## Application for a Non-Material Amendment Following a Grant of Planning Permission

Ridley Mill House

Demolition of existing extension to the rear and erection of proposed extension to the rear.

20/02656/FUL

Sheet Title
 Proposed North and South Elevations

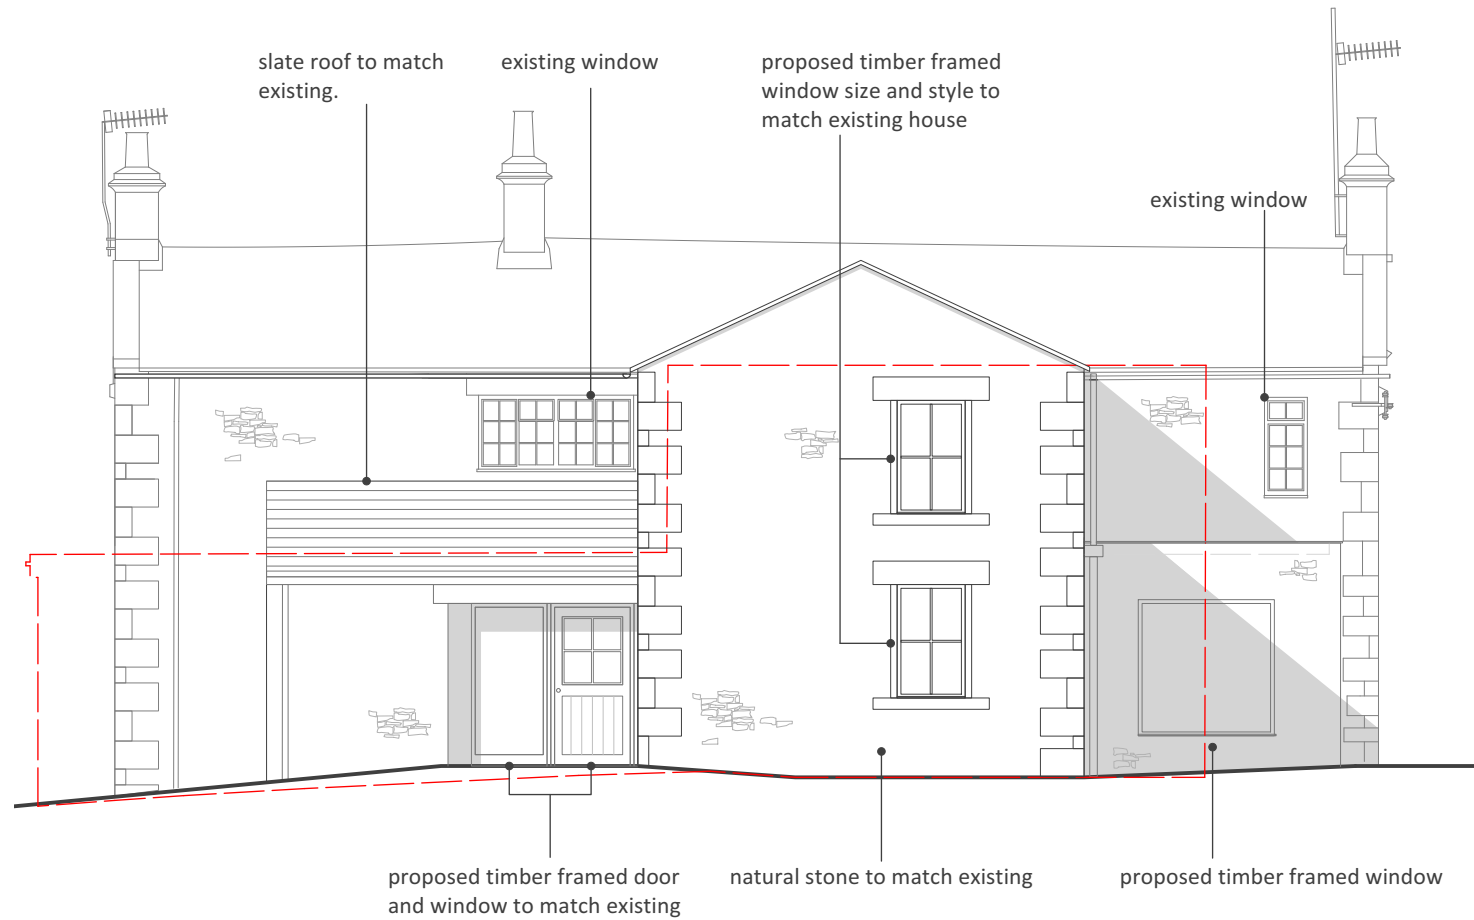
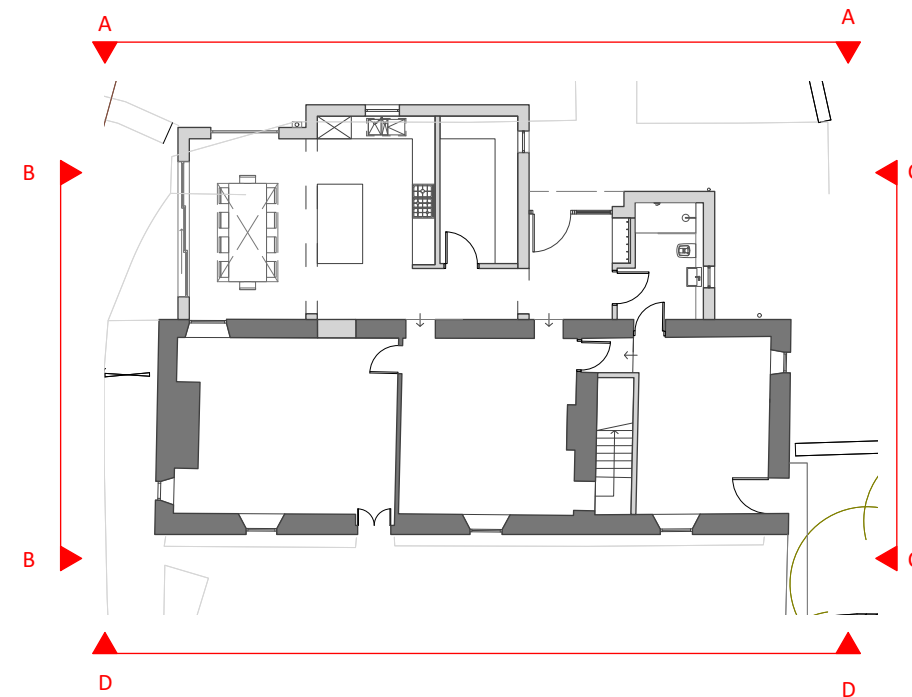
Removal of projecting timber frame surround to Dining Room window within proposed single storey extension. The size of the window opening and its position remains the same.

Proposed Alteration of box window - the revised design seeks to remove the projection so the window would be flush with the wall. The window will not be altered in size or materiality. Therefore, I advise the following is submitted:
